P/125/21/HH

Neals Farmhouse West Wing Lower Bognor Road Lagness Chichester PO20 1LW

Alterations to fenestration (This application may affect the setting of a listed building)

Proposed Elevations

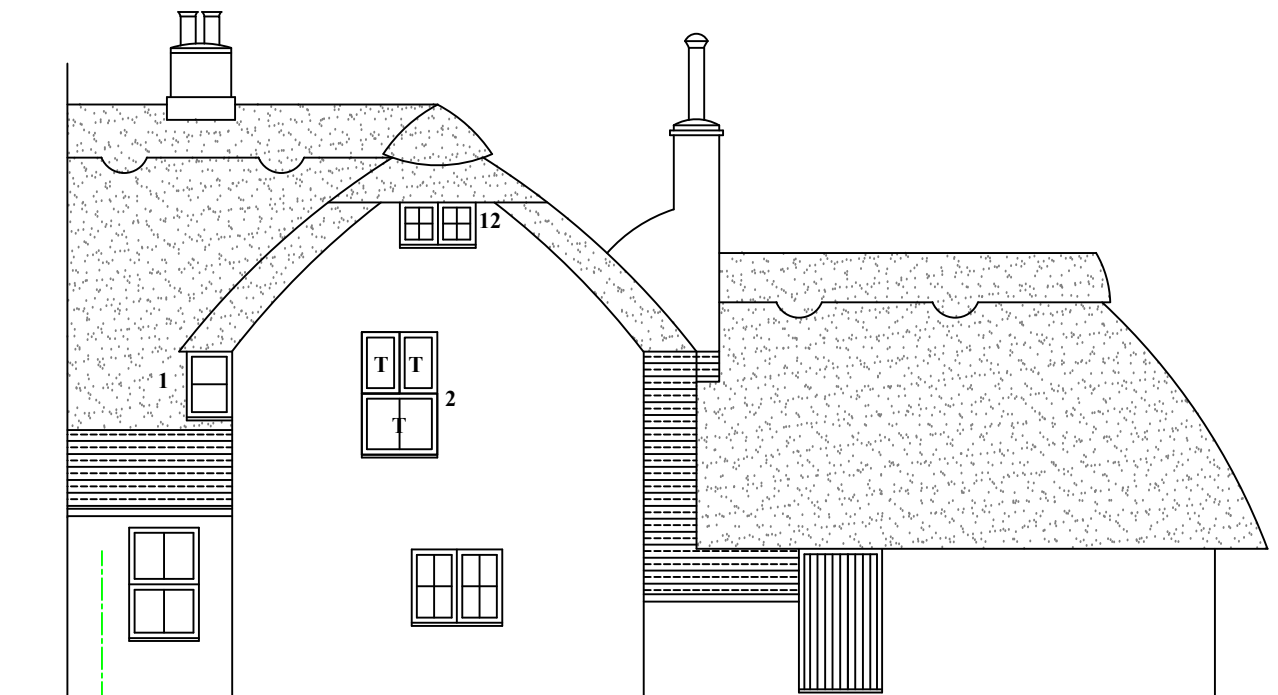
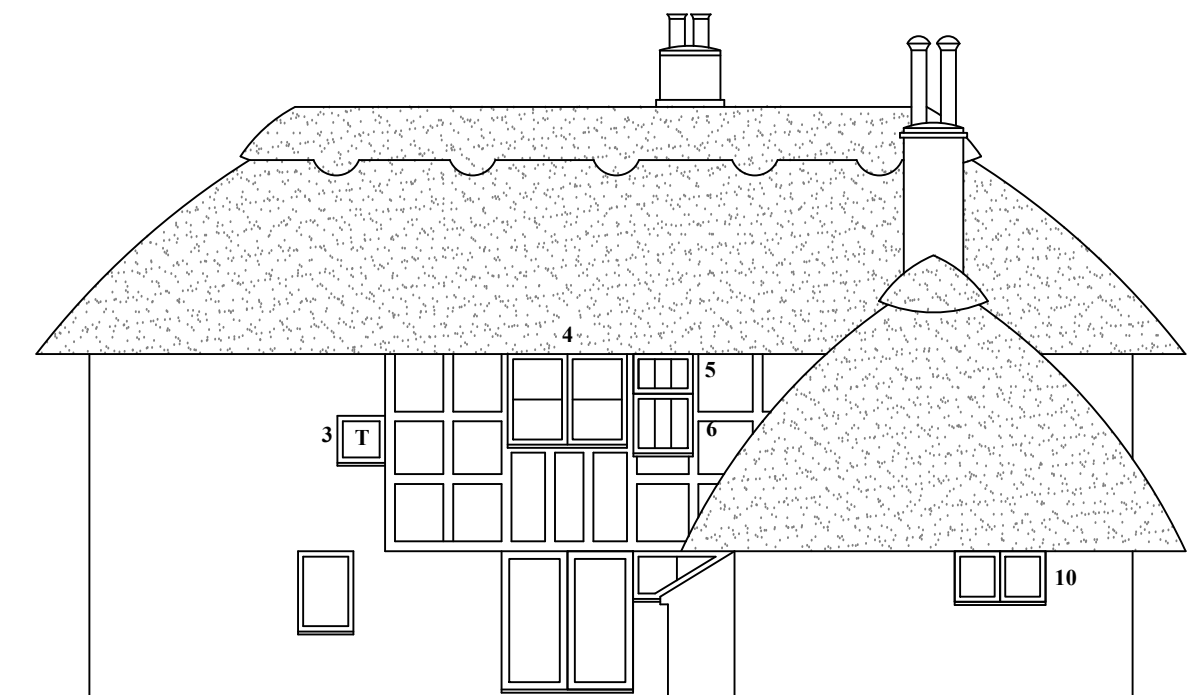
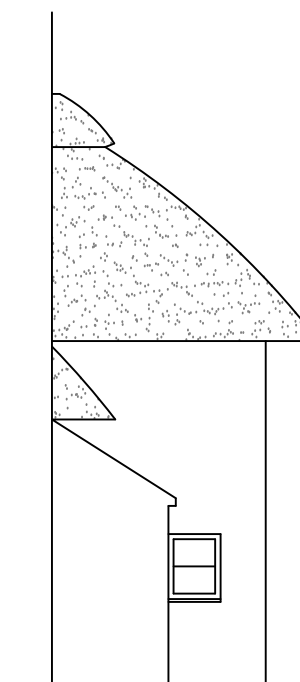
When submitting a listed building consent application for replacement windows it is essential that adequate information is included to assess the proposal. In addition to existing and proposed elevation drawings, large-scale section drawings will be expected. The heritage statement should identify the age and significance of the windows to be replaced, as well as provide information regarding their condition. This information has not been provided as part of this application which makes an assessment difficult.

The replacement windows incorporate standard thickness double-glazed units (24mm thick) which are not acceptable in a listed building. Such windows appear very obviously double-glazed. Aspects of their finer detailing such as prominent spacer bars and applied glazing bars can appear incongruous in the context of a listed building. It is also not clear if the windows are of a storm-proof or flush mounted design as only simple elevations are proposed.

In conclusion based on a lack of information along with the use of an inappropriate glazing system, the currently application is considered to be harmful. The proposal is such that the impact can be described as causing less than substantial harm in accordance with paragraph 202 of the NPPF (2021). As such, you will also need to consider the public benefits that the development may achieve as part of your assessment of the application, along with the contents of the Planning (Listed Buildings and Conservation Areas) Act 1990 (as amended).
